10 October 2012.

**61 MOBBS LANE, EPPING – SUBDIVISION AND VISITOR CAR PARKING SPACES (MP10\_0158)**

B B8 EAST P1
1:200

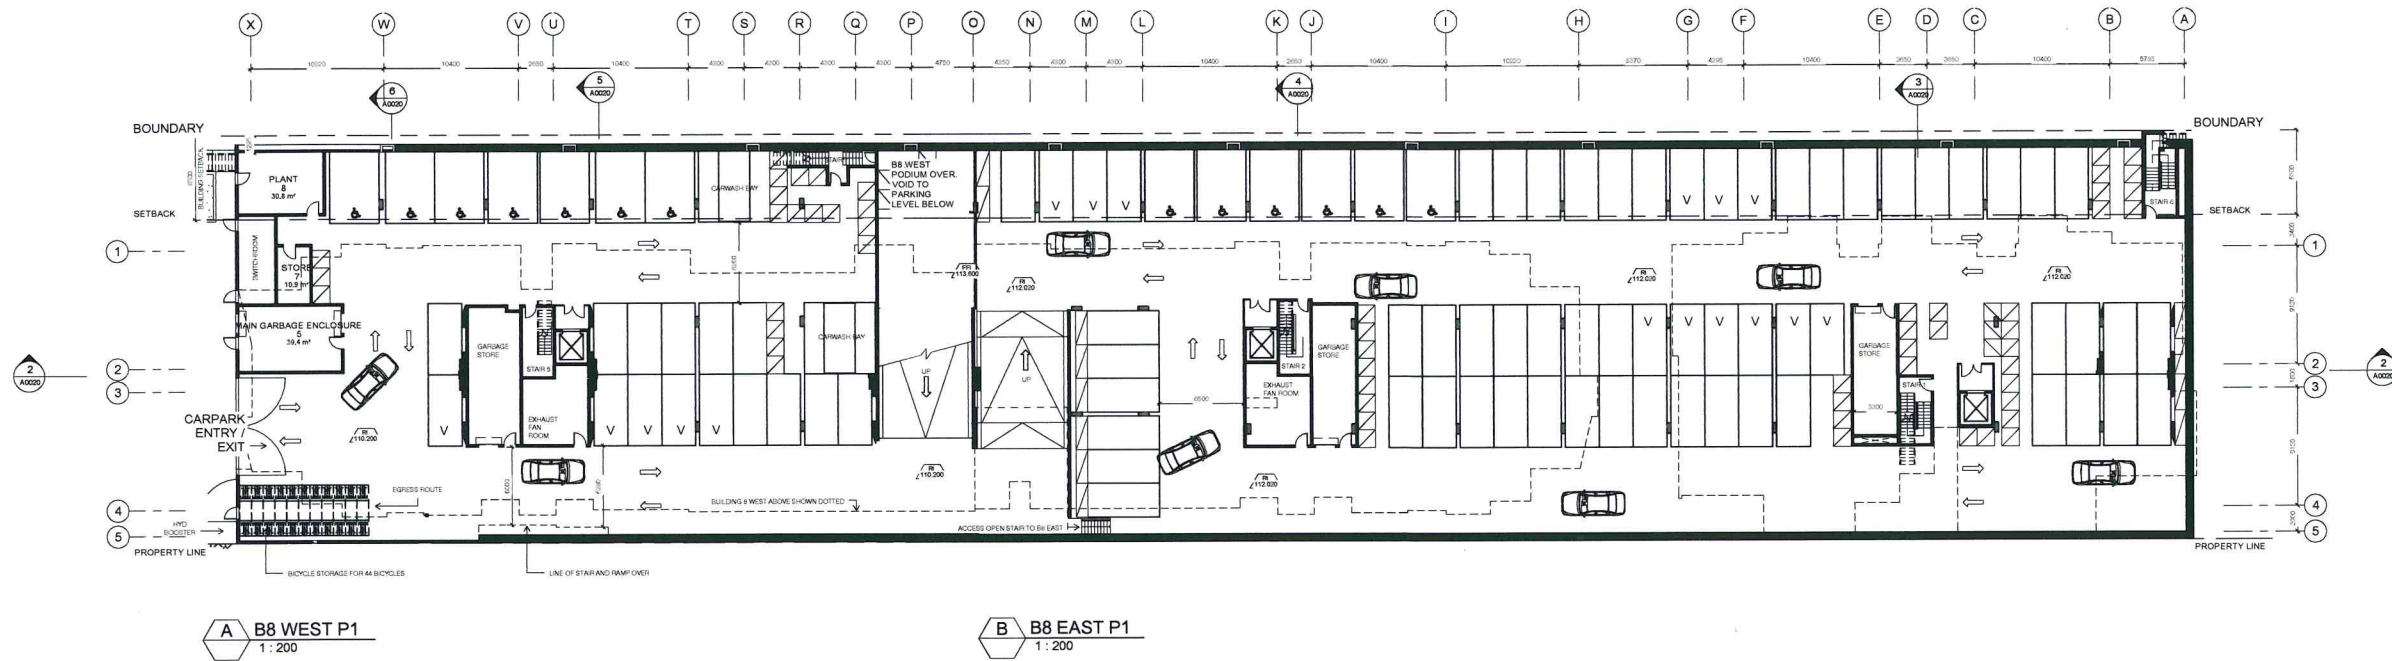
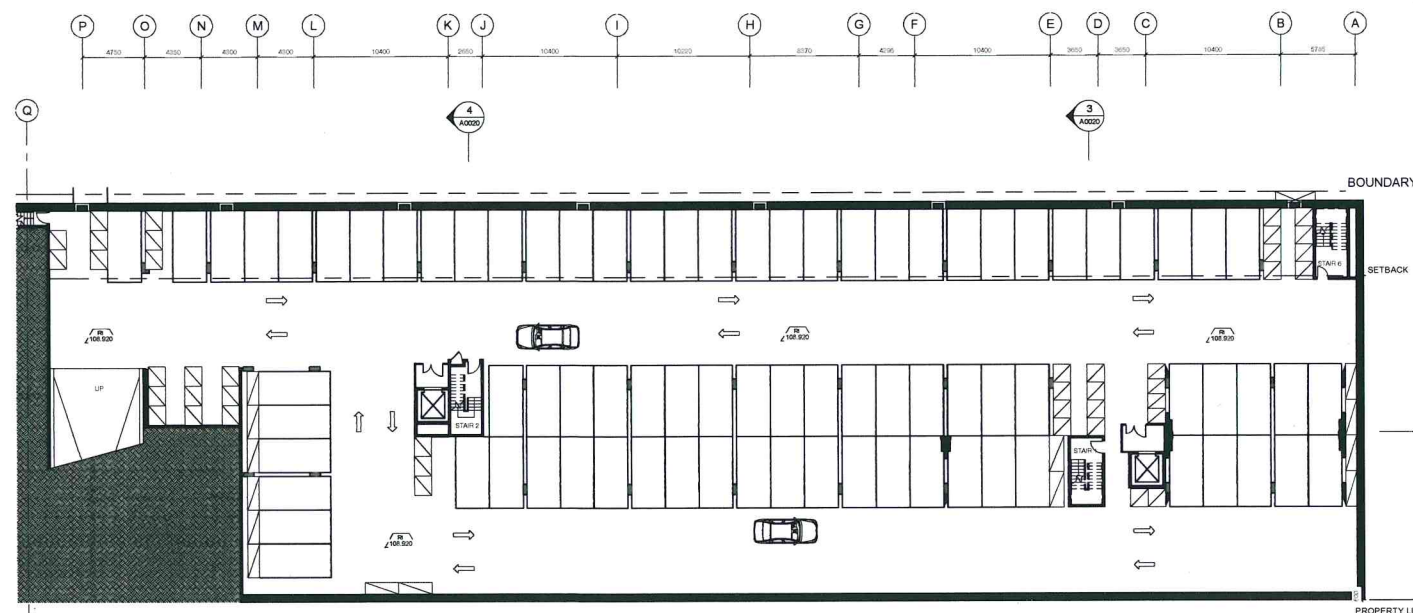
The condition as currently worded would have all 17 visitor car parking spaces located in one area, rather than dispersed around various lift cores as shown on the attached architectural plan (**Annexure 1**). By having all visitor car spaces located under Building 8 visitors will have difficulties with accessing units in Building 7. Under this scenario all visitors would access one lift into the western side of Building 8, which does not provide internal access to Building 7. This will create confusion for visitors and will significantly hold up the travel time of the lift for Building 8. Visitors will then try to walk within the basement to find the correct exit to Building 7, which will be dangerous due to pedestrian/vehicle conflicts, using internal car ramp and the like.

Overall, the design of this basement is unusually long due to the layout of the original Concept Approval, which is resulting in the need to better group visitor car spaces around all lobbies.

Accordingly, we seek the agreement of the Director General to have visitor car spaces in accordance with that shown on the plan in **Annexure 1**, as permitted by Condition A10 (refer **Annexure 2** for a copy of Condition A10).

Sheet 4 of the approved strata plan does not have to change as the visitor spaces are notated as a CS (car space) as shown on the plan. Furthermore, the number of visitor car spaces at 17 remains compliant with the Major Project Approval for Buildings 7 and 8.
